Application No: BR/213/21/HH
Site Address: 12-14 The Steyne Bognor Regis PO21 1TP
Description of works: Erection of front porch extension, installation of first floor double balcony and external facade alterations (This application may affect the character and appearance of The Steyne, Bognor Conservation Area)

Thank you for your internet representation made on 30th October 2021 which has been recorded as no objection with the comments as follows:

TITLE:
Existing Plans and Elevations

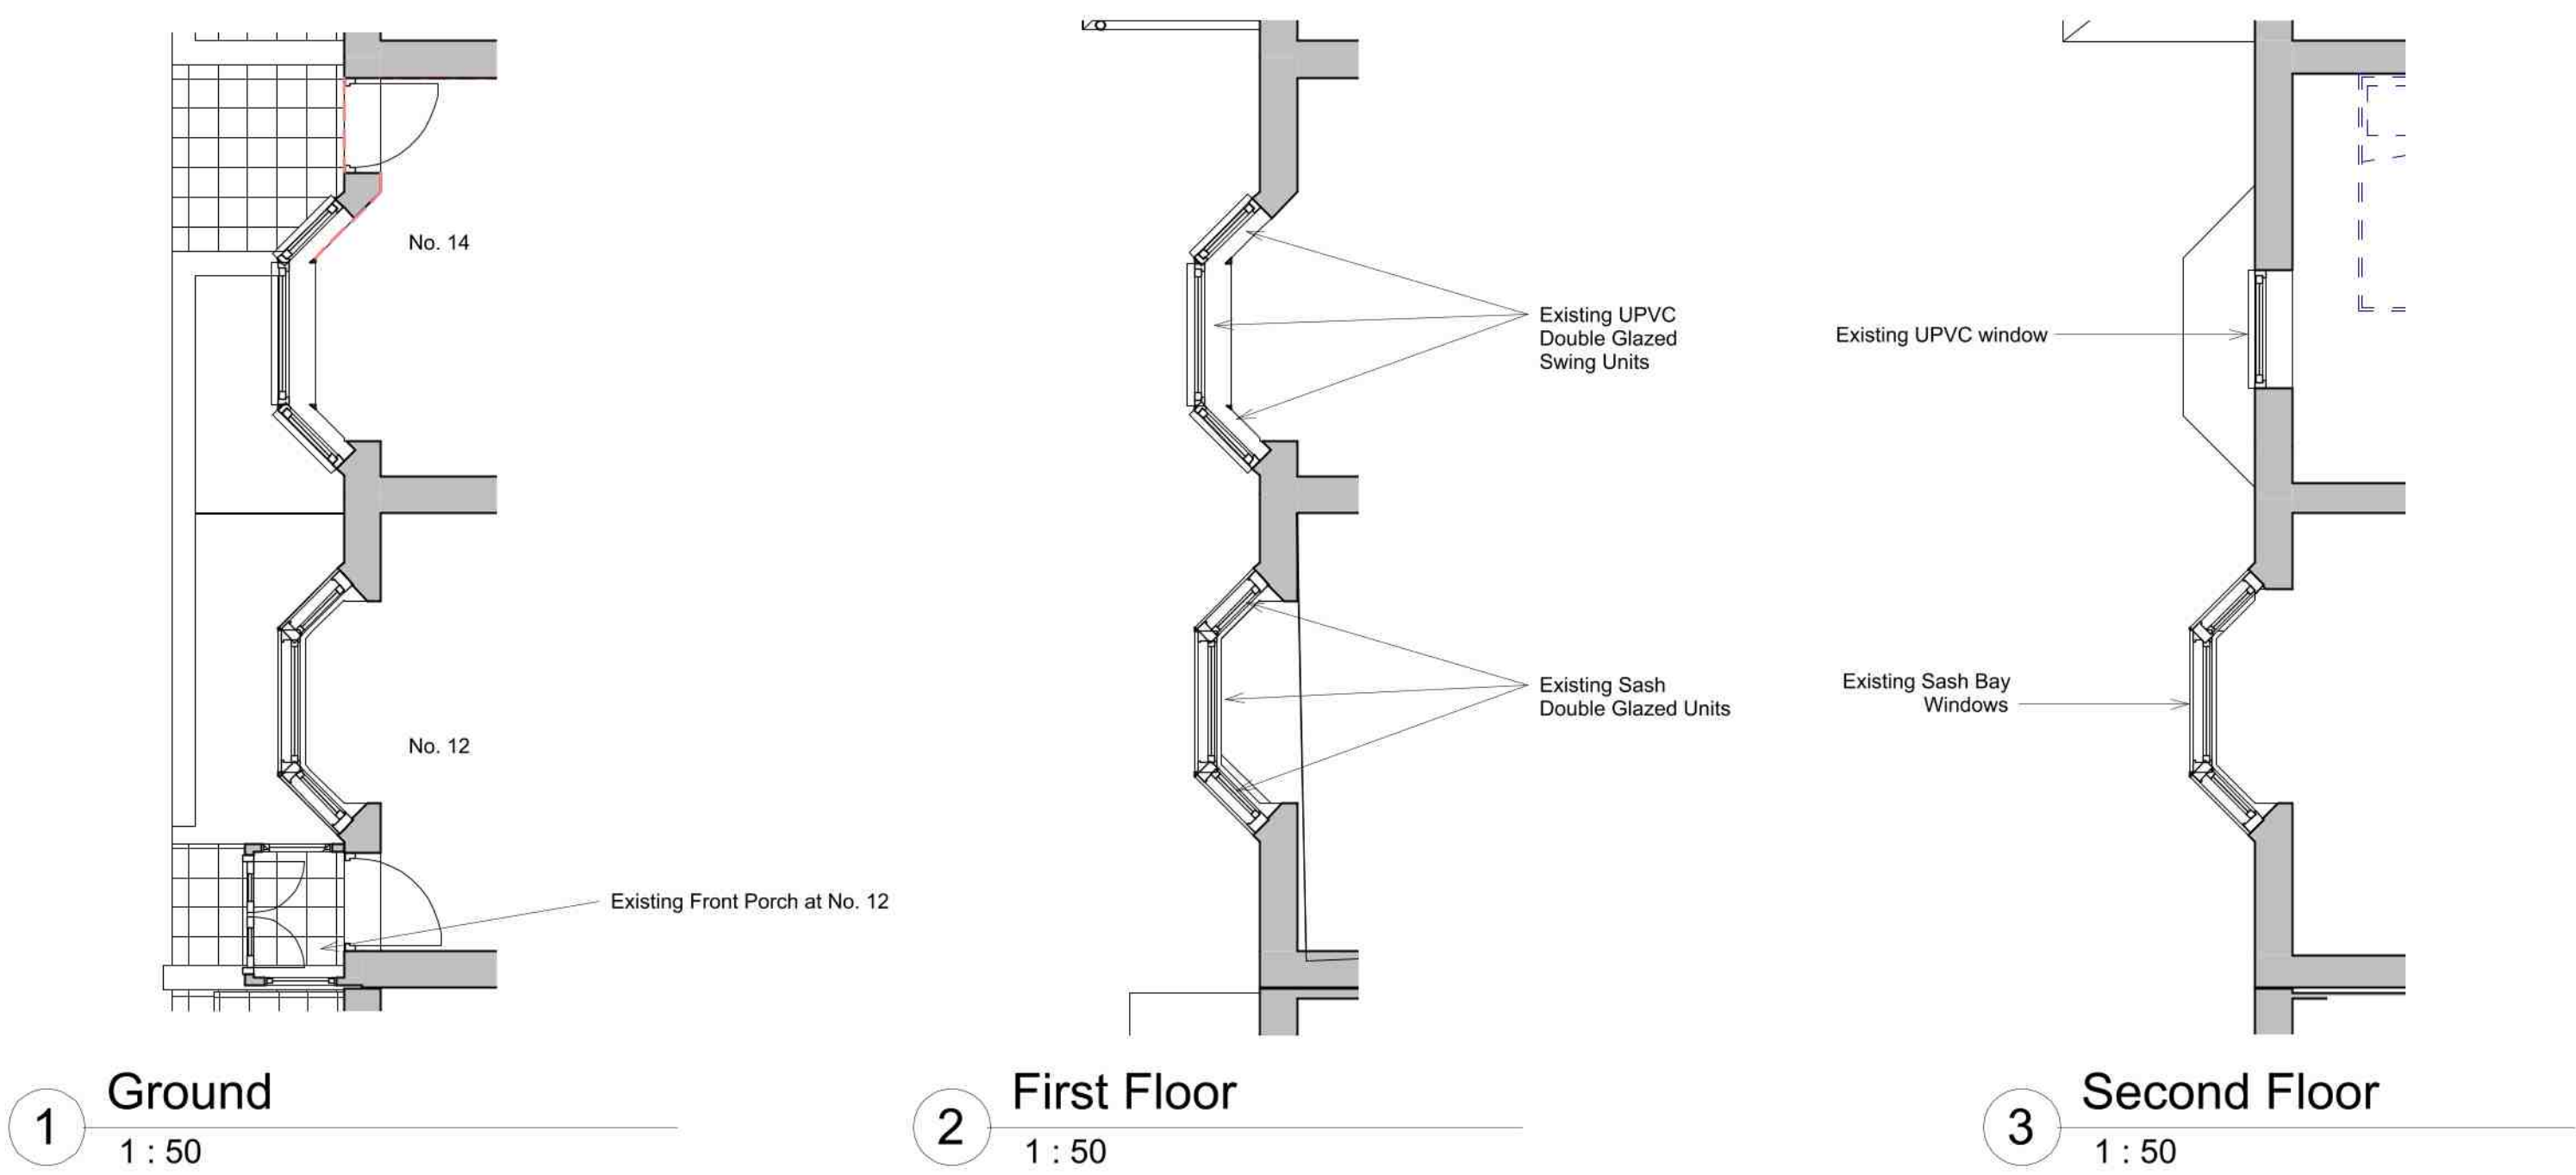
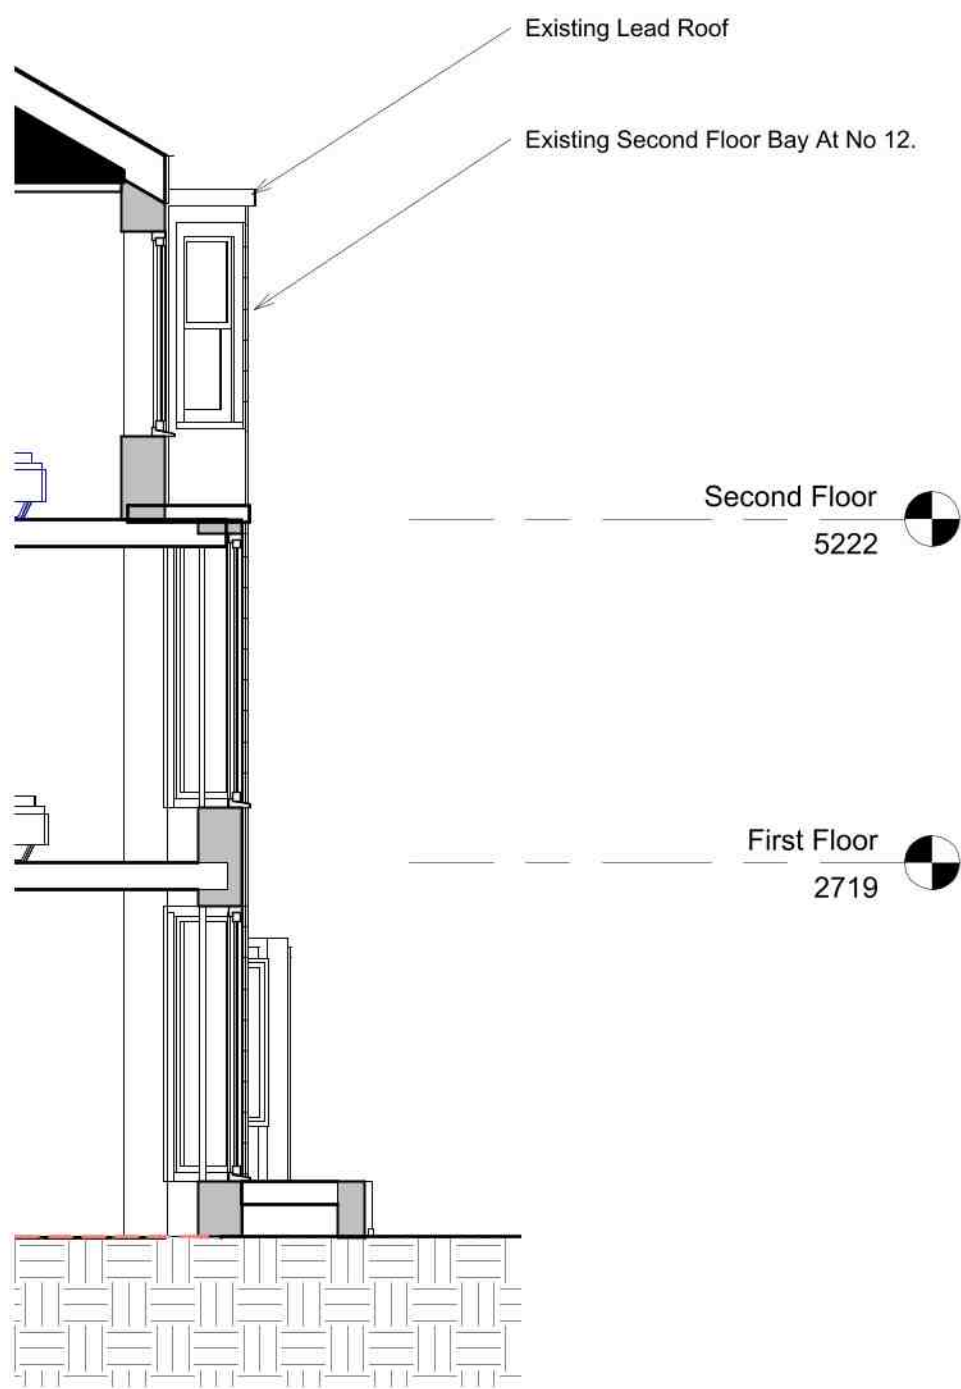
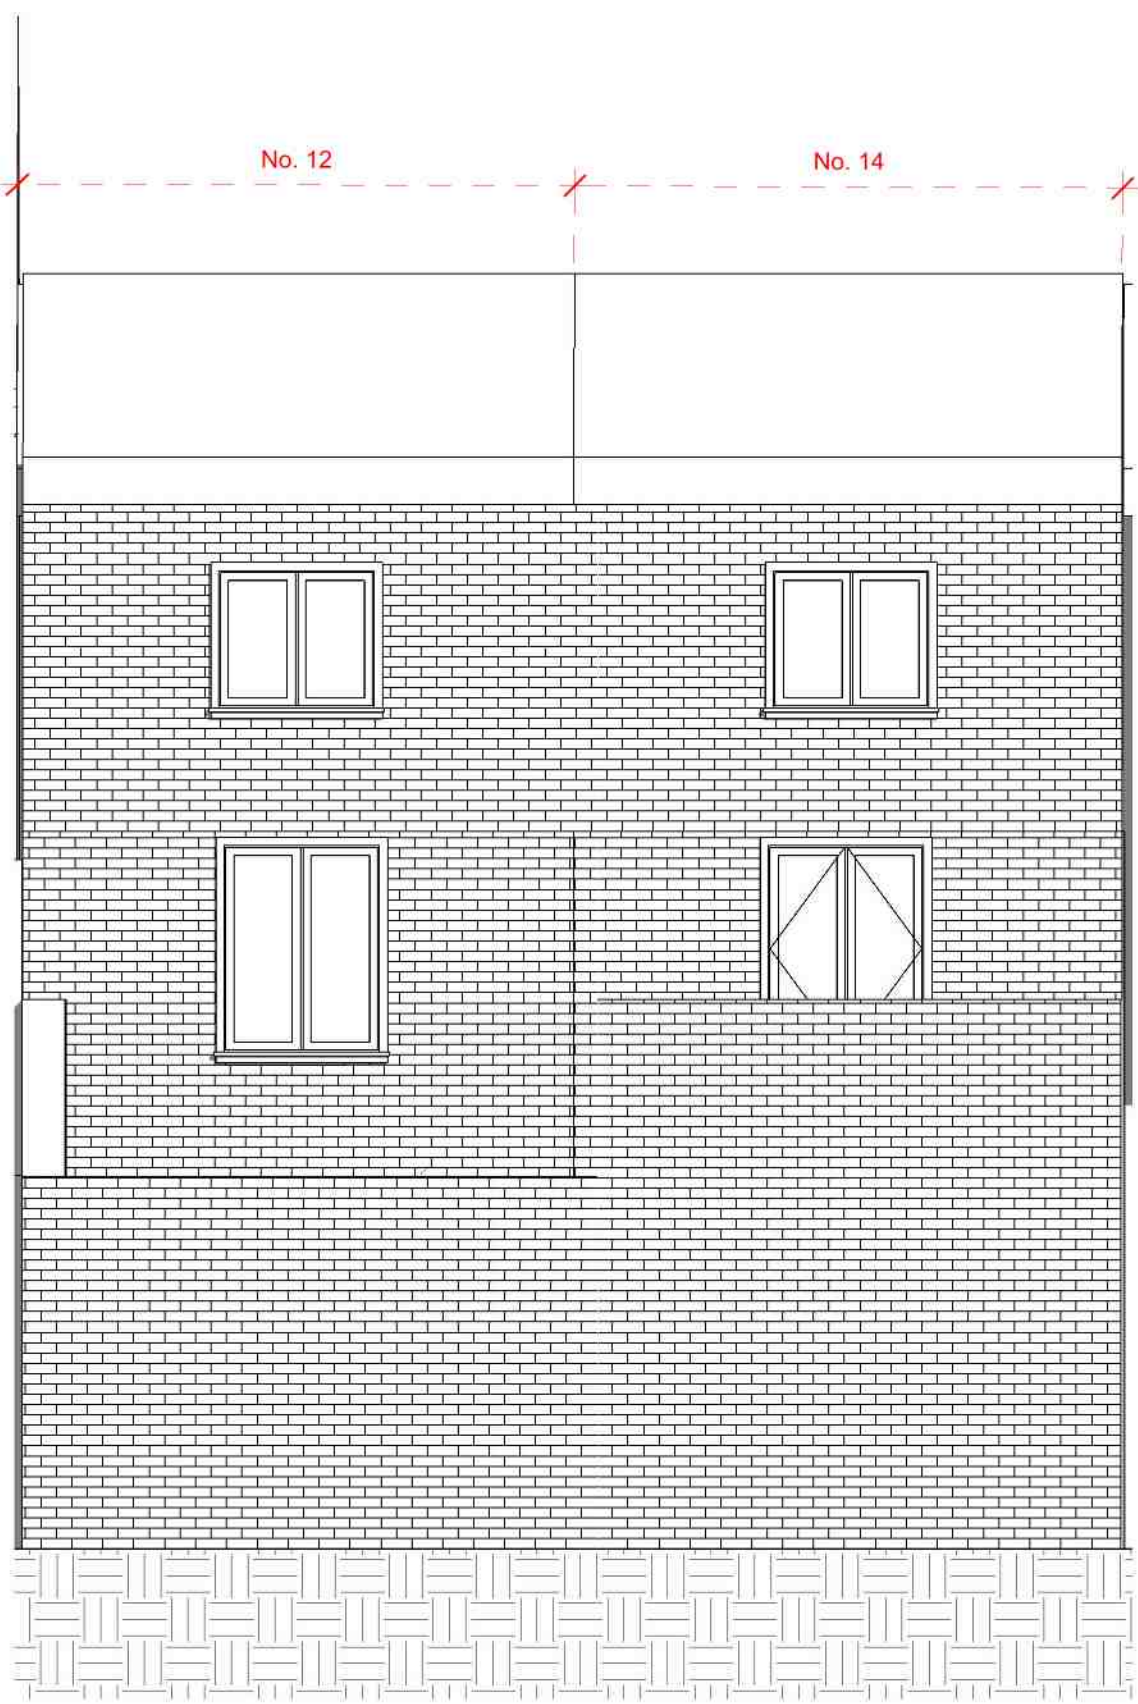
Nos 12-14 are 3 storey early 19th Century plain regency style dwellings which have been somewhat adversely altered with the replacement of the original painted timber sash windows with pvcu units and the construction of front porches.

The Panel would have preferred to see the complete removal of the two front porches since they are not appropriate to the period and architectural style of the buildings and they crowd the attractive angled bays. An original rendered doorway hood still survives at no 12 which could have been replicated at no 14 and then with the provision of two painted timber six panel doors recessed in the original doorway openings a considerable visual improvement would have been made to the two properties.
